Development Assessment and Planning

08/04/2013 DAP083-13

**Project Application Stage 1 - Retail / Club Precinct, Cronulla Sharks -
Captain Cook Drive, Woollooware**

File Number: **DN13/0006**

The Waterfront is a pocket park that links the Deck to the Foreshore Walk. It is a grassy slope and that spills down from the cafes and restaurants. It is a slow space, where people can enjoy a moment outside. It is a place to sit in the sun or a place for kids to play while mum has a coffee.

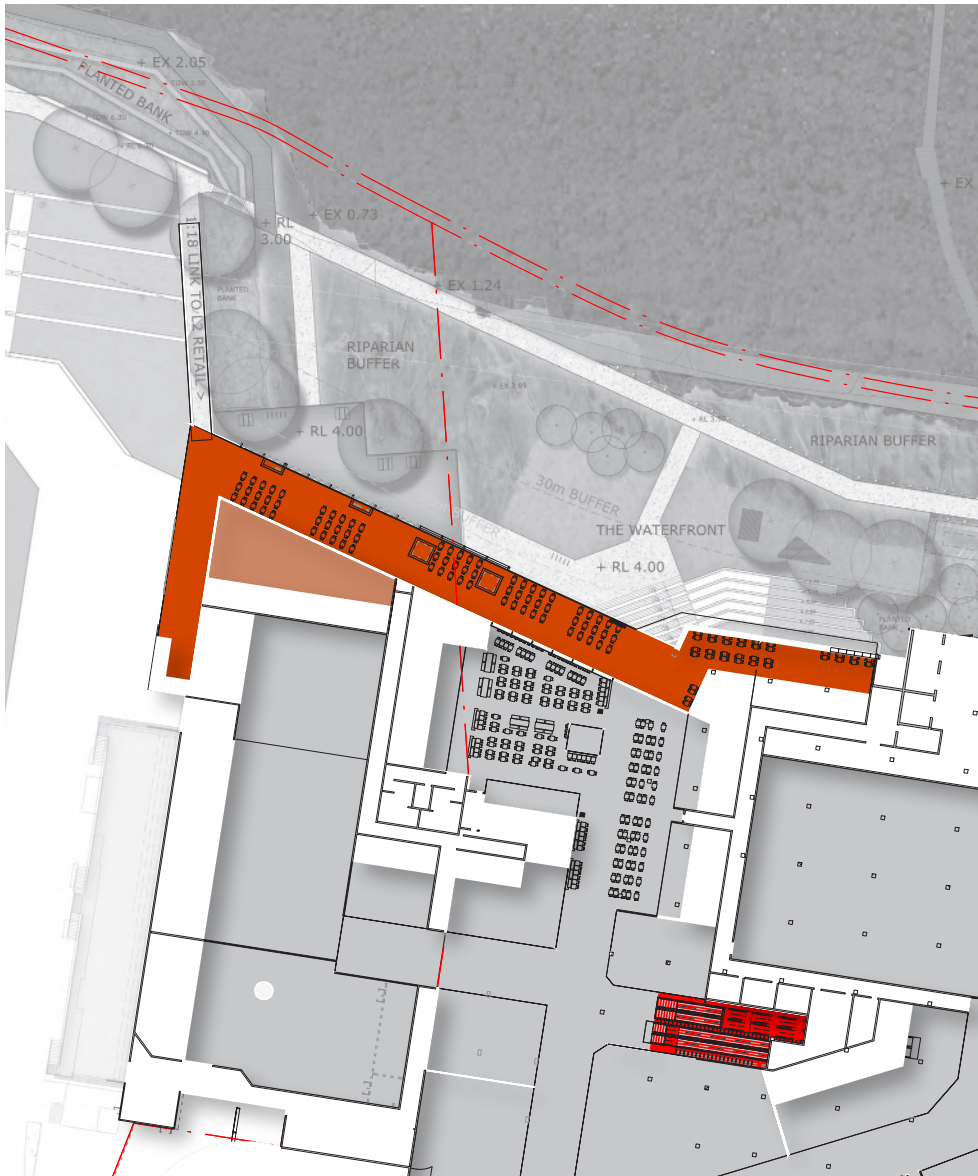
The proponent's design intrudes into the riparian buffer zone with a number of built structures including a Woollooware Road, retaining walls, concrete access paths, decking and benches. The terraced steps between the mall and the riparian zone also encroach into the riparian zone with an unnecessarily grand/formal transition between the mall and the riparian zone.

TYPICAL SECTION - WOOLLOOMARE ROAD NORTH

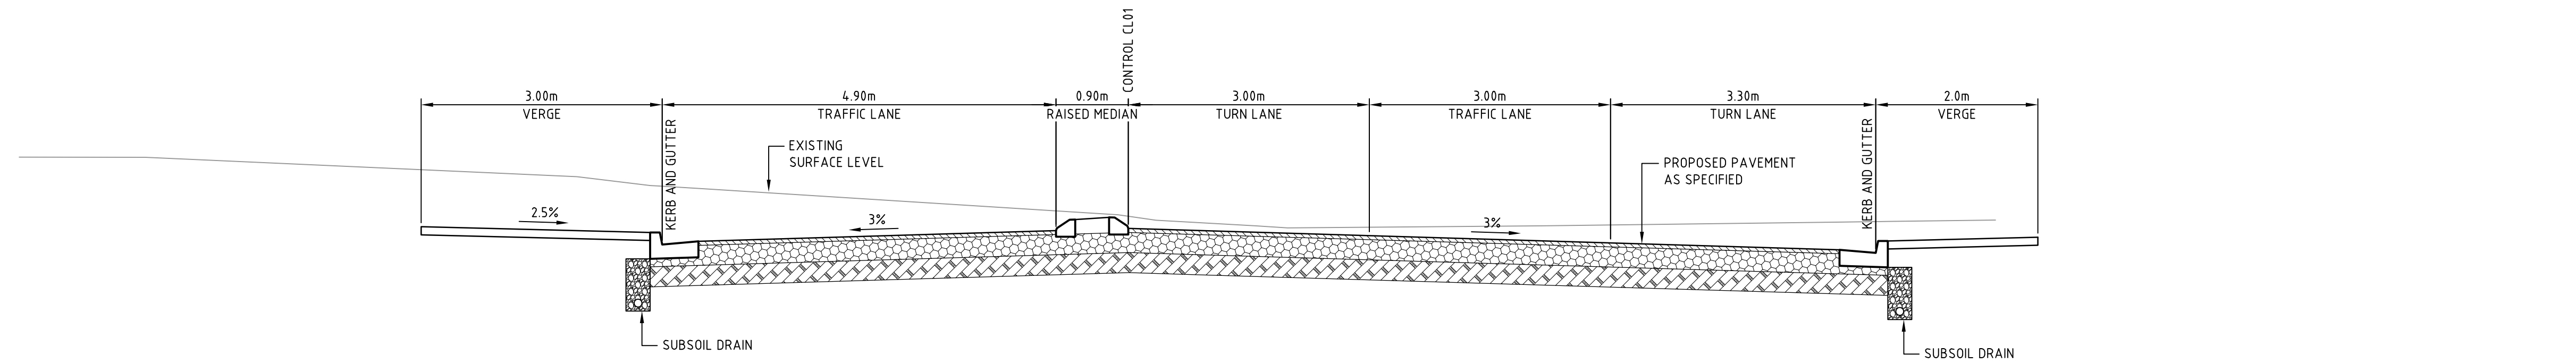
The retail/club development plans indicate a road (marked Woollooware Road North) and cul-de-sac adjoining the site. The PAC report, which considered the Masterplan design, included the following comment with regard to this matter:

Woollooware Road north, and the associated turning circle measure a distance of only 2.5m from the Mean High Water Mark, which is a substantial 37.5m encroachment into the 40m riparian buffer zone. The NSW Office of Water *Guidelines for riparian corridors* recommends that infrastructure such as roads, drainage, stormwater structures, services or the like not be located within these areas.

- The road labelled Woollooware Road North provide a minimum 40m riparian zone buffer.
- Minimal built structures be located within the riparian buffer zone, including stairs, paths, retaining walls, playground equipment and the like.
- That large tree species from the Swamp Oak Forest and Swamp Schlerophyll Forest species list are incorporated into the landscape design where they can be provided clear of the transmission line easement or within height limitation within the easement.
- Water Sensitive Urban Design is incorporated into the design scheme.
